**Subject:** Rezoning Petition Review

**Date of Review:** April 28, 2022 (*Revised May 25, 2022*)

**Rezoning Petition #:** 21-257

**Location of Property:** Approximately 52.67 acres locate on the west side of Amos Smith Rd and southeast side of Old Dowd Rd, west of I-485.

Conceptual Site Plan

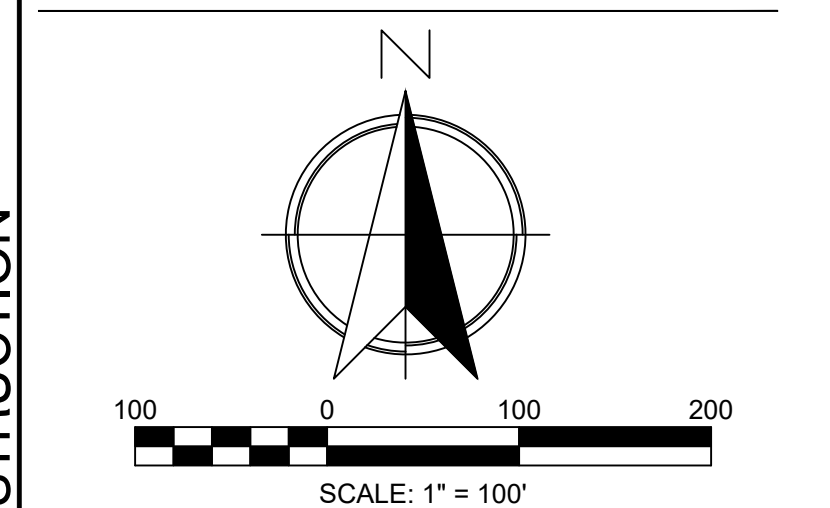
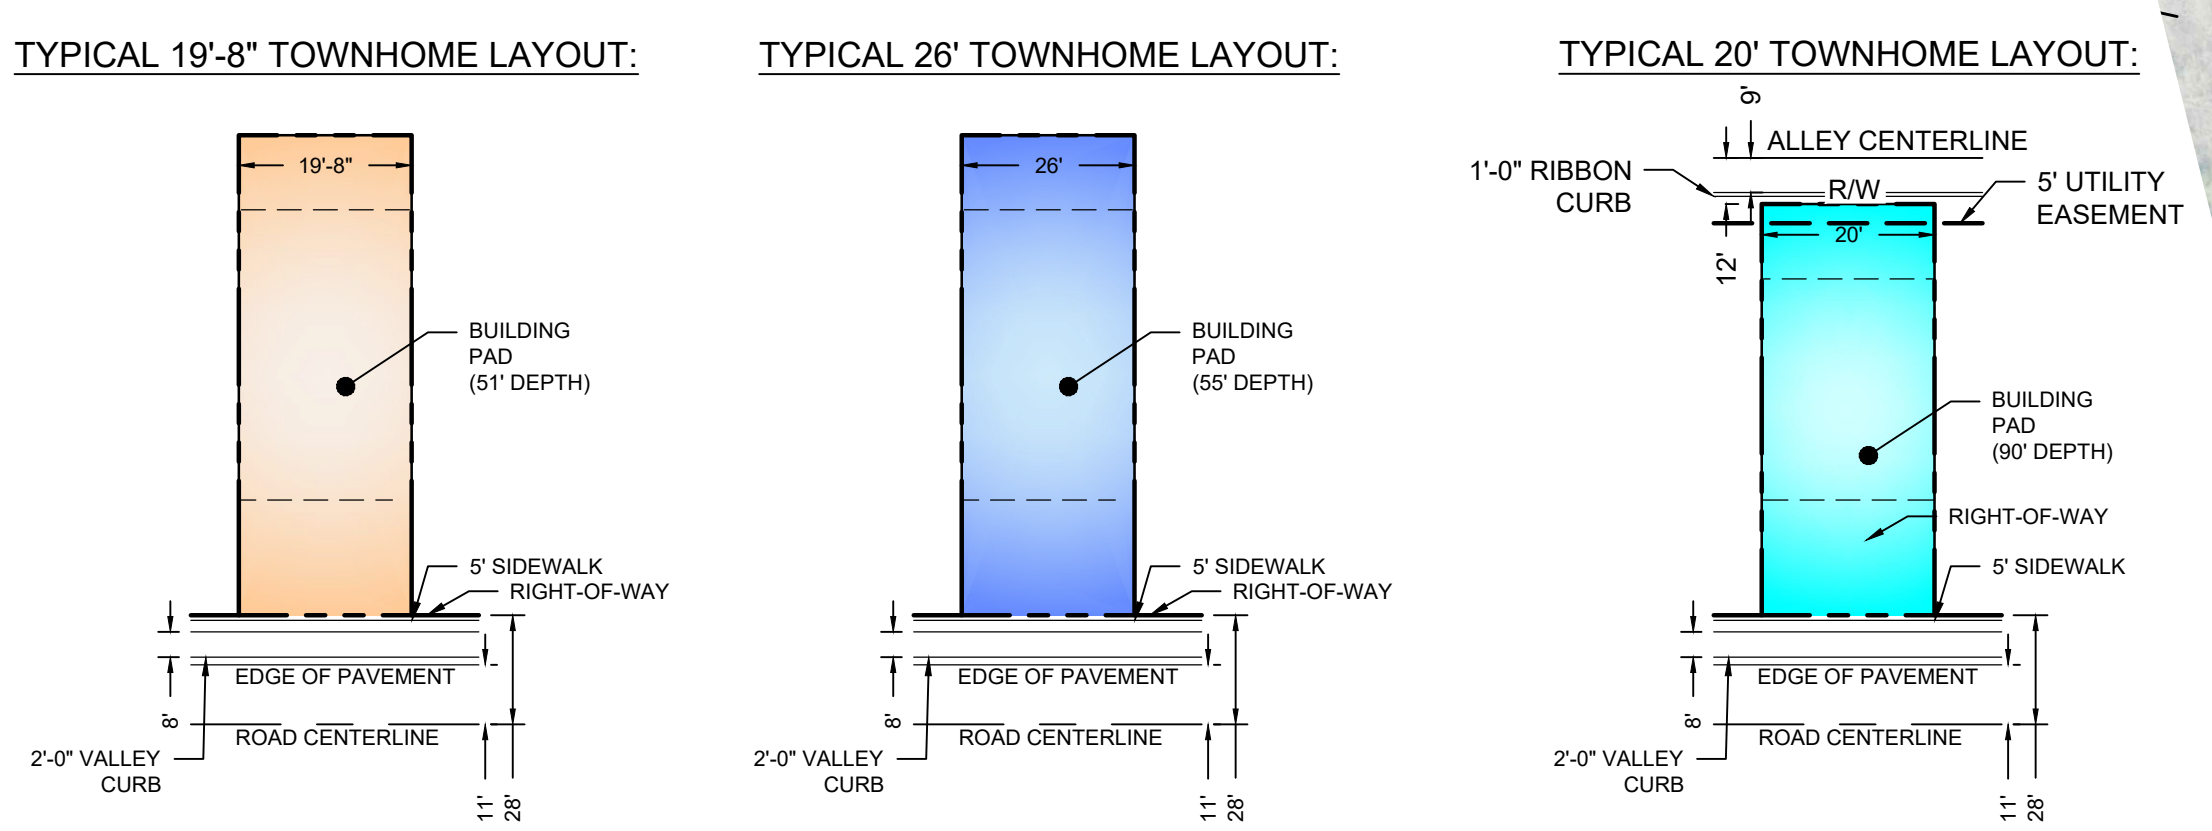
Revised rezoning sheet 1.0 has removed a potential 30-ft PCSO buffer from the plan and now indicates several building structures within the limits. Please show this 30-ft PCSO buffer on the plan sheet and include the following note under Environmental Features: *“Development within any SWIM/PCSO Buffer shall be coordinated with and subject to approval by Charlotte-Mecklenburg Storm Water Services and mitigated if required by City ordinance. Petitioner acknowledges intermittent/perennial stream delineation reports are subject to review and approval upon submission of development plans for permitting and are not approved with rezoning decisions.”*
